Design and Access Statement Plot B - Addendum

01997-WEA-OXFORD NORTH PLOT B-DAS-ADDENDUM-P02

This document is an addendum to the Plot B Design and Access Statement, 01997-WEA-OXFORD NORTH PLOT B-DAS-P01 submitted to Oxford City Council in March 2023 and Addendum P02 submitted in June 2023.

Following the initial Oxford North Plot B Reserved Matters Application submission further amendments have been reviewed following ongoing engagement with the specialist contractors. Issues were raised regarding buildability and embodied carbon which have led to a number of small amendments to the initial scheme.

KEY

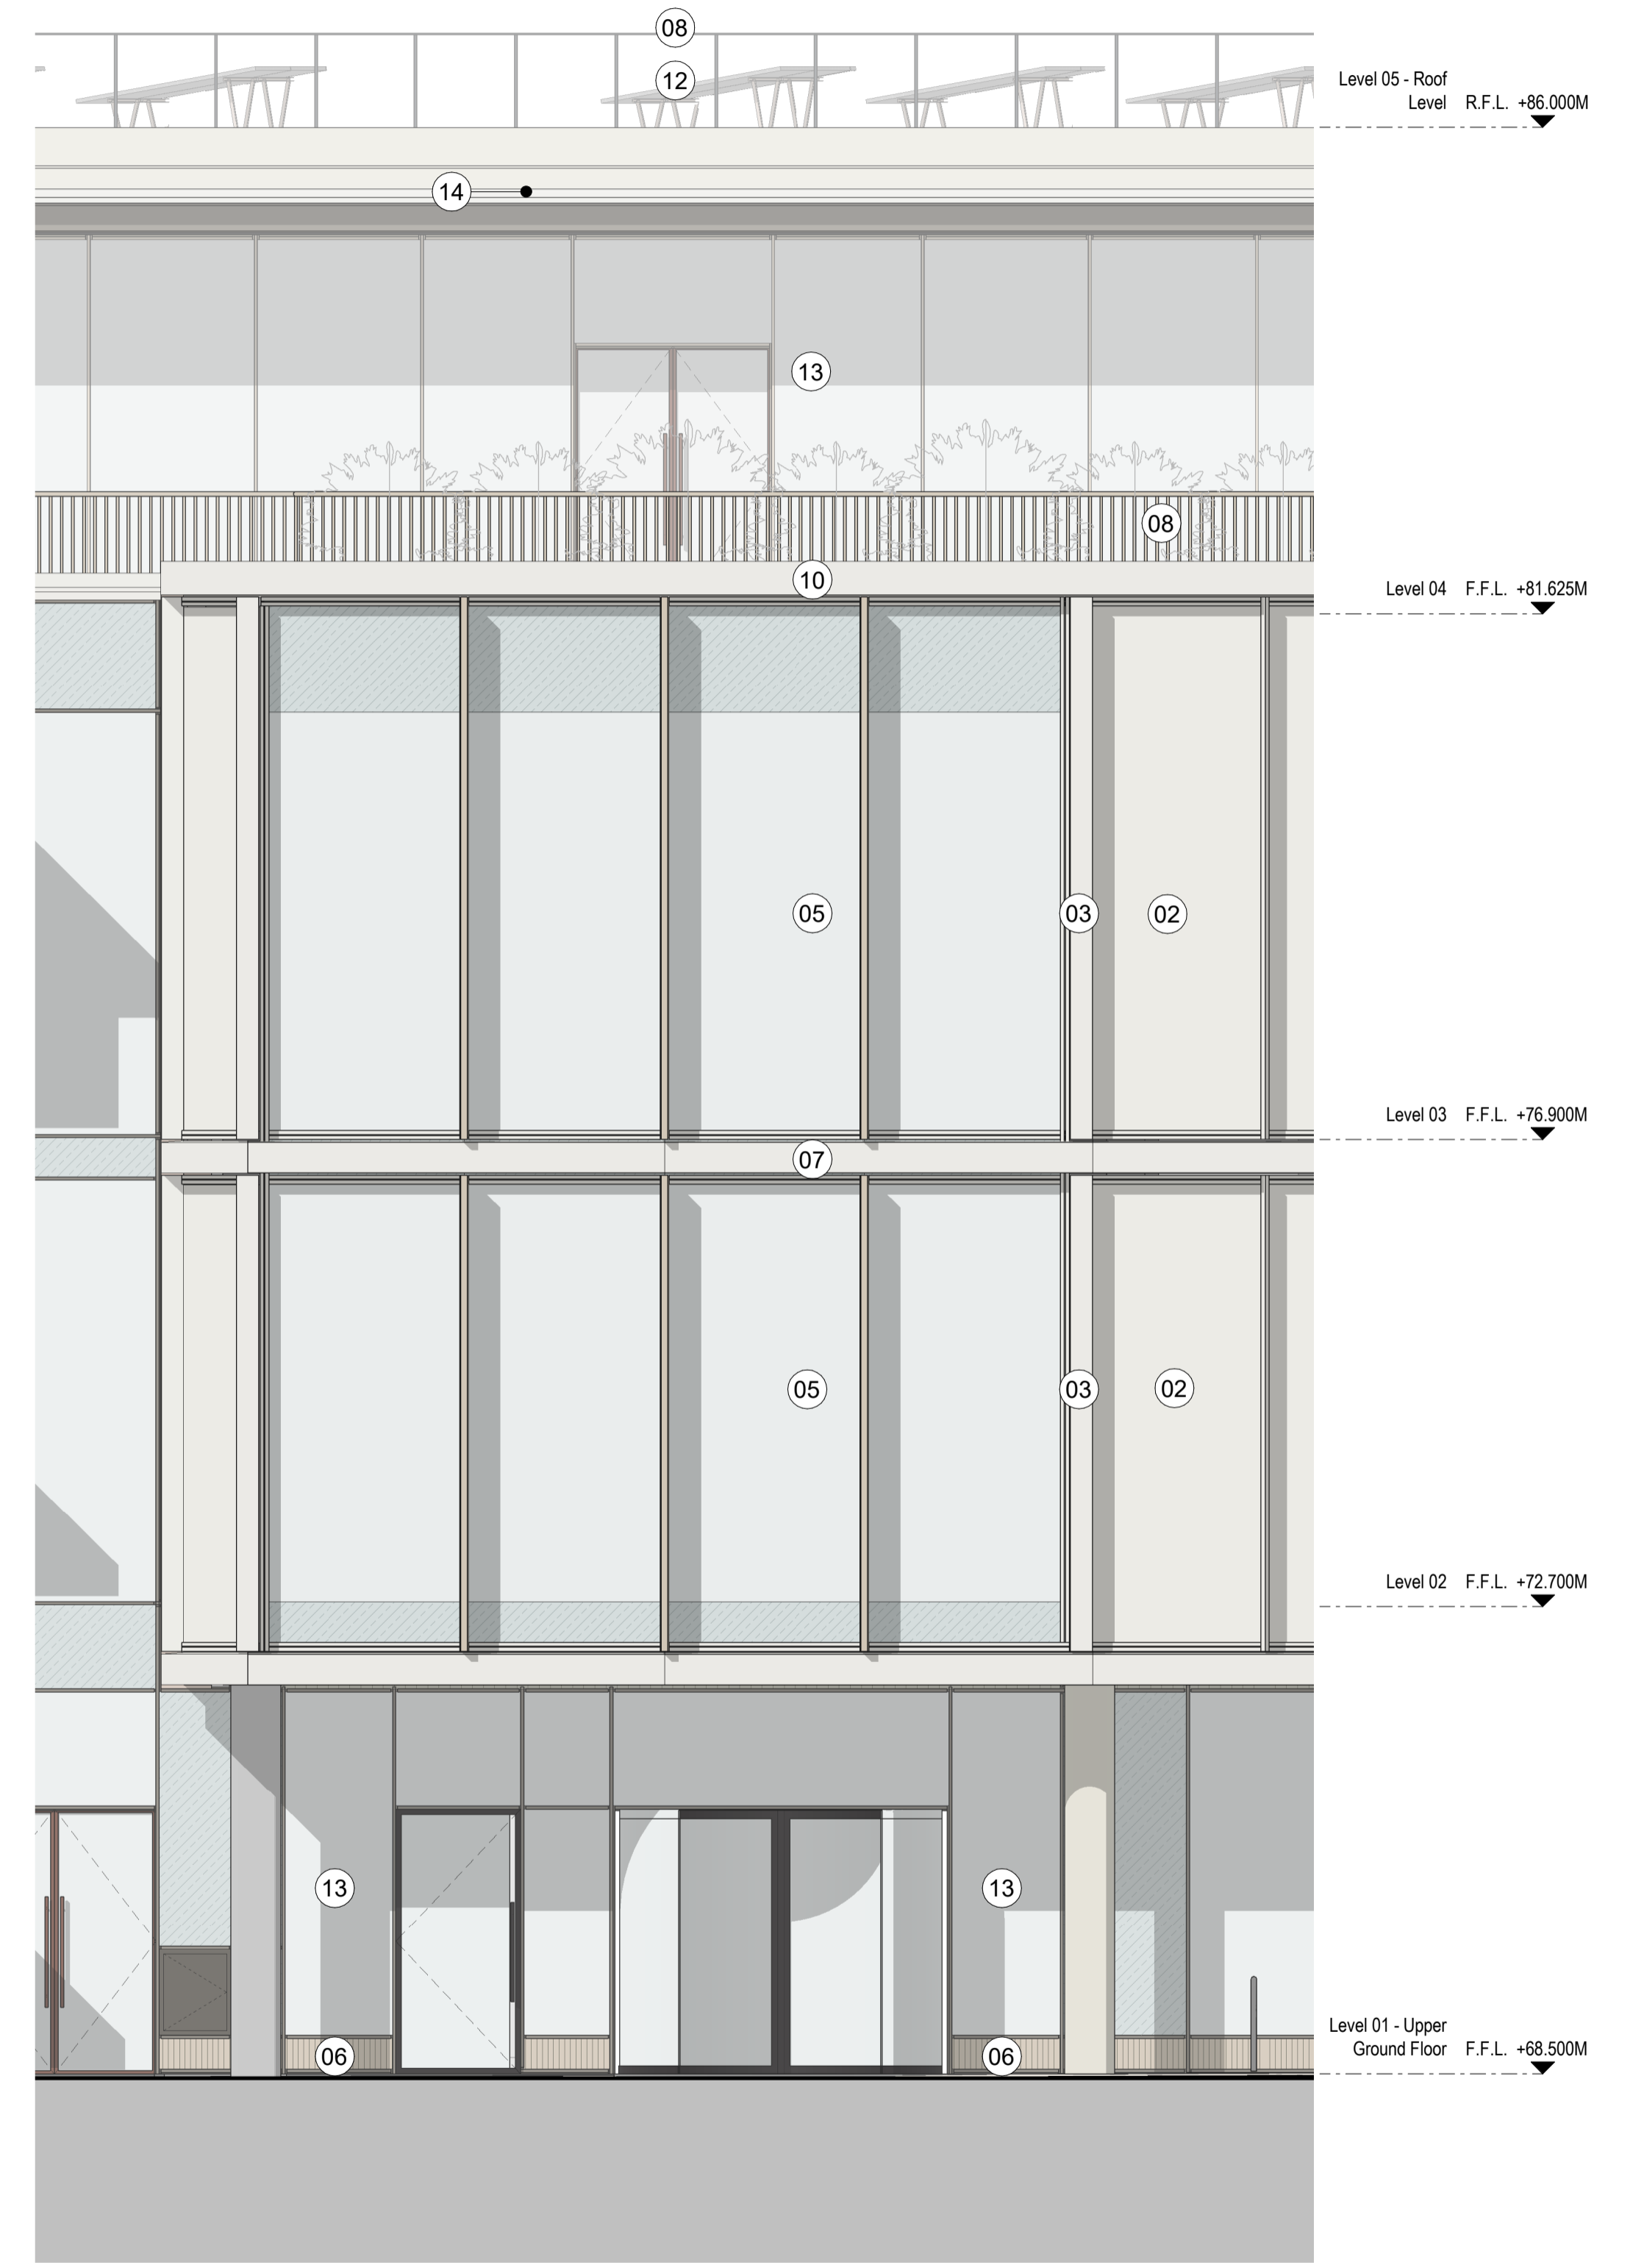
The key change to the scheme has been the reworking to the eastern end of the north wing to the building. Following buildability reviews with the preferred main contractor, the acute junction of the entrance elevation was identified as an area of significant complexity and difficult construction detailing. Therefore the design team reviewed an alternative orientation of this facade that was also considered could improve the composition of the forecourt space.

By amending the angle of the return elevation it was felt this entrance facade better framed the external forecourt space. As well as removing the awkward angle, it was felt the visibility of the entrance screen was improved. The width of the glazing screen was increased to provide a more open and transparent frontage. It was considered that this would enhance the relationship between the internal and external spaces.

The re-working of the entrance facade also involved amending the flat areas of cladding and provide more articulation through the use of vertical fins. This was intended to enhance the elegance of the facade and was adopted as common approach to each of the wing gable end elevations.

01- Square up building to East of North wing (over the main entrance)

02- Amend entrance screen to be wider and not recessed with canopy removed below.

04- Flat cladding to gable end amended to vertical fins and setting out consistent along elevation
